Final Report - Corrections Required **Application No. DEPN-25-0173**

Report Date: 06/02/2026

Document Filename : V3. Development Plan_Rock Creek.pdf

DP2.01

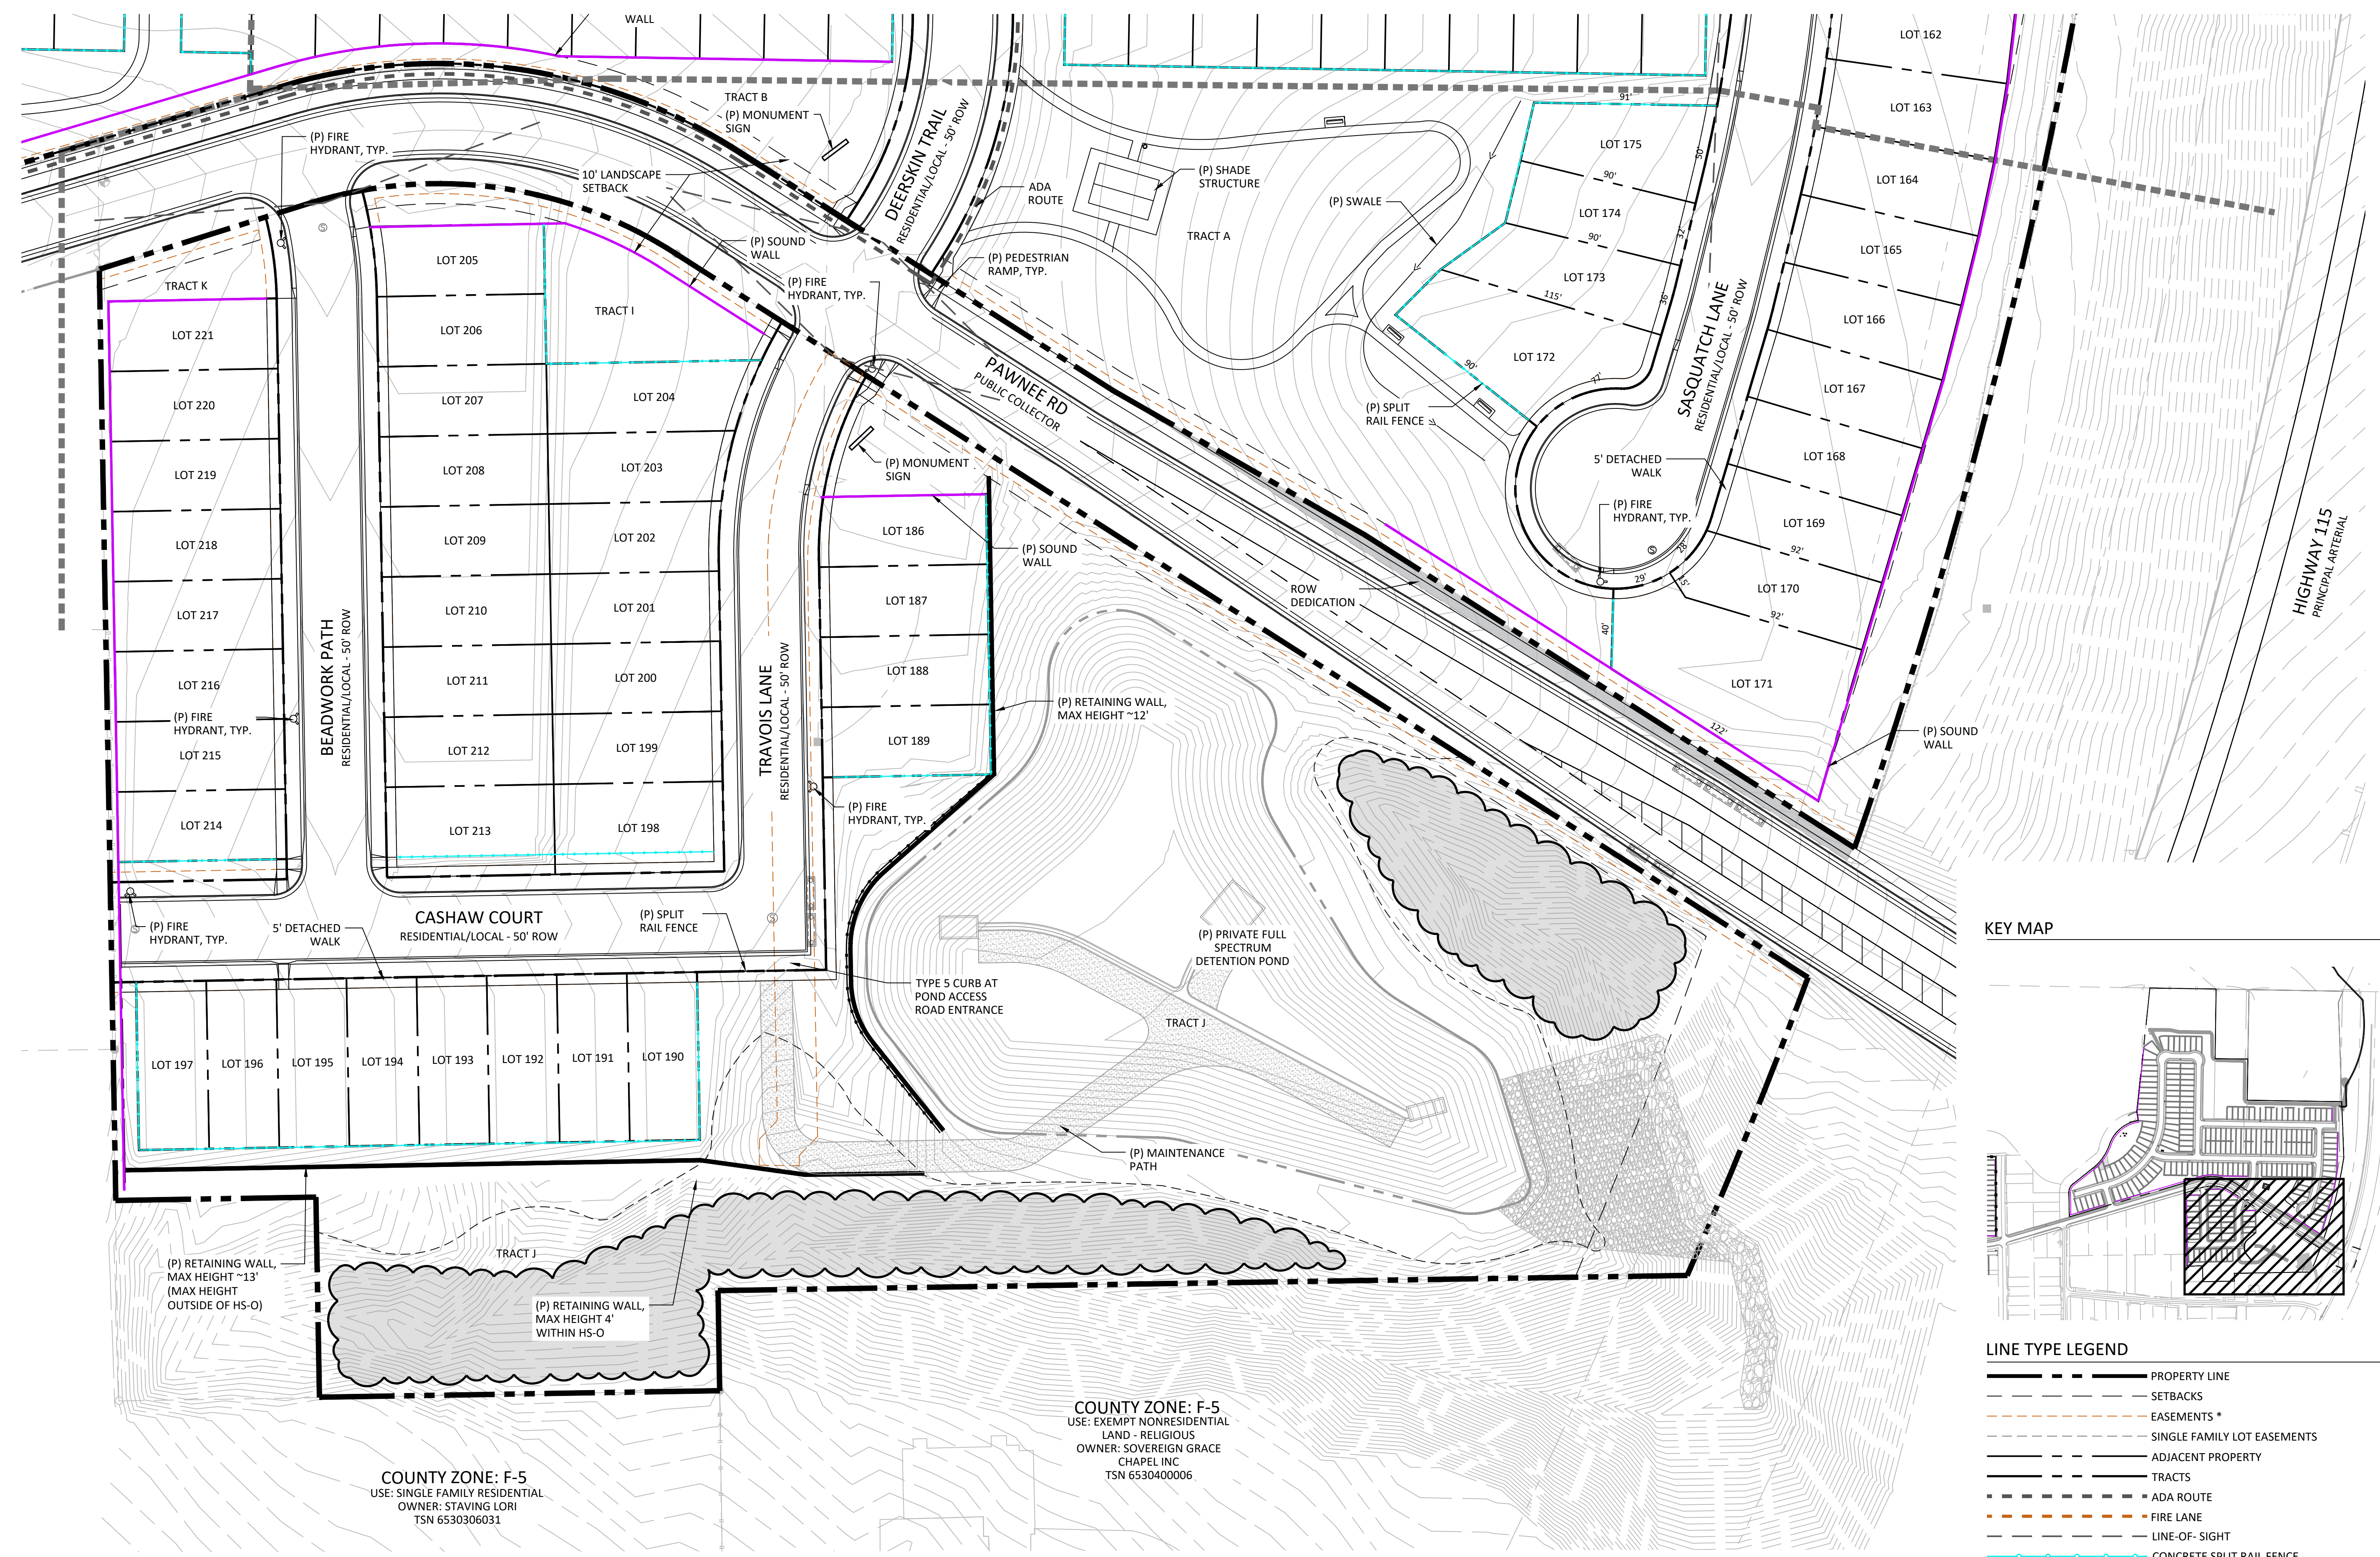
282	1	Caroline Miller : Planning	What is this PK Zoning label referencing? PK is to the north of this parcel.
283	1	Caroline Miller : Planning	If Single Family Attached is no longer proposed, please remove Propose Use type.
284	1	Caroline Miller : Planning	Please remove unit type if Attached Homes are no longer proposed.
285	1	Caroline Miller : Planning	Informational - An updated PLDO Fee and Citywide Development Impact (Police & Fire) Fee estimate will be uploaded upon next review, reflecting only detached SFH, and the removal of the attached townhomes.
287	1	Caroline Miller : Planning	Reviewer is awaiting School District follow-up from applicant, Markup ID 237 Applicant response. Additional notes may be added upon communication by the district.
288	1	Caroline Miller : Planning	Tract F square footage detailed calculates to 2.12 acres, please confirm.
292	1	Kerri Schott : Planning	Awaiting County re-review comments, if any, as of 5/29/26. Once received, Planning staff will pass on to the applicant as soon as possible.

DP2.06

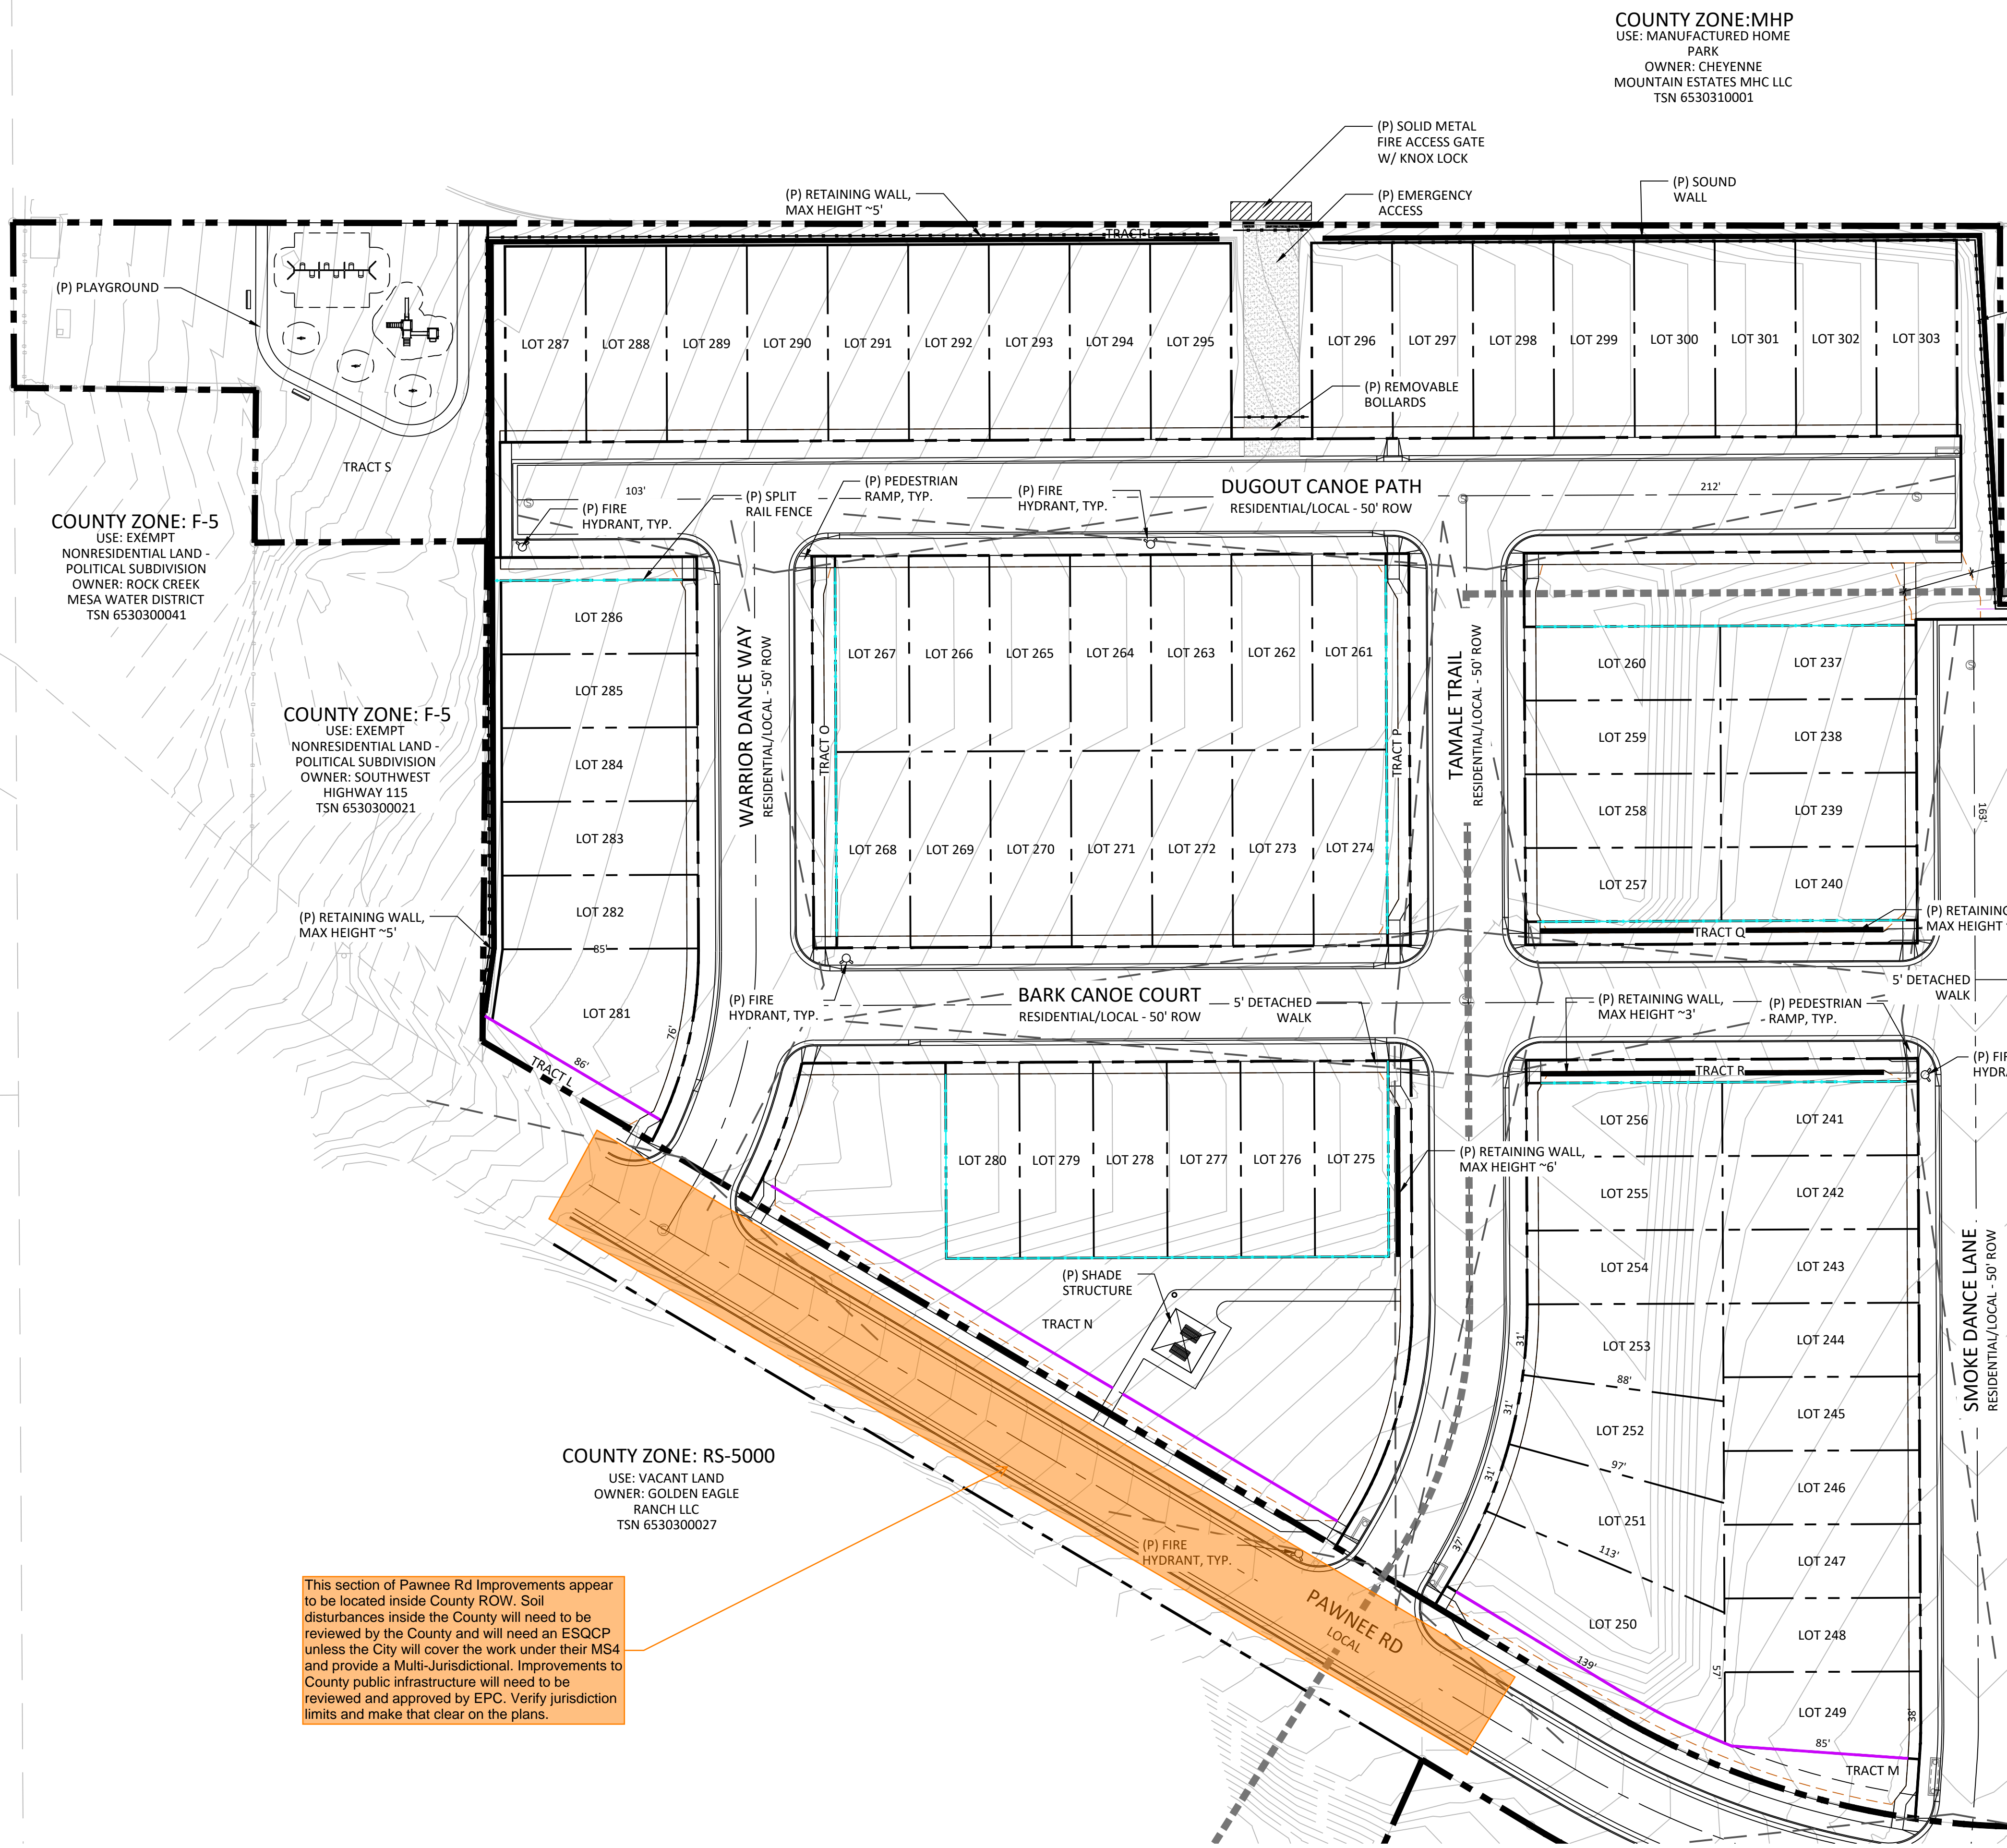
264	8	Joel Dagnillo : City Engineering Dev Review	Add a note stating that driveway location for Lot 233 must be specifically shown on construction plans to ensure no conflict with mid-block pedestrian ramp
266	8	Joel Dagnillo : City Engineering Dev Review	Since Commanche Rd. is now a City-owned roadway and it is adjacent to development, public improvements must be installed. Please show a City Std. Type 1 or 2 curb/gutter and a 5' detached or 6' attached public sidewalk adjacent to Commanche Rd. In addition, there will be landscaping requirements as communicated by the City Senior Landscape Architect.
271	10	Patrick Dosch : Col Springs Utilities	Previous comment partially addressed: Please show the conceptual location of the gas and electric meters on the lot typical. Please show the conceptual locations of water and wastewater services. Please label and dimension horizontal clearances of the services and curb stops
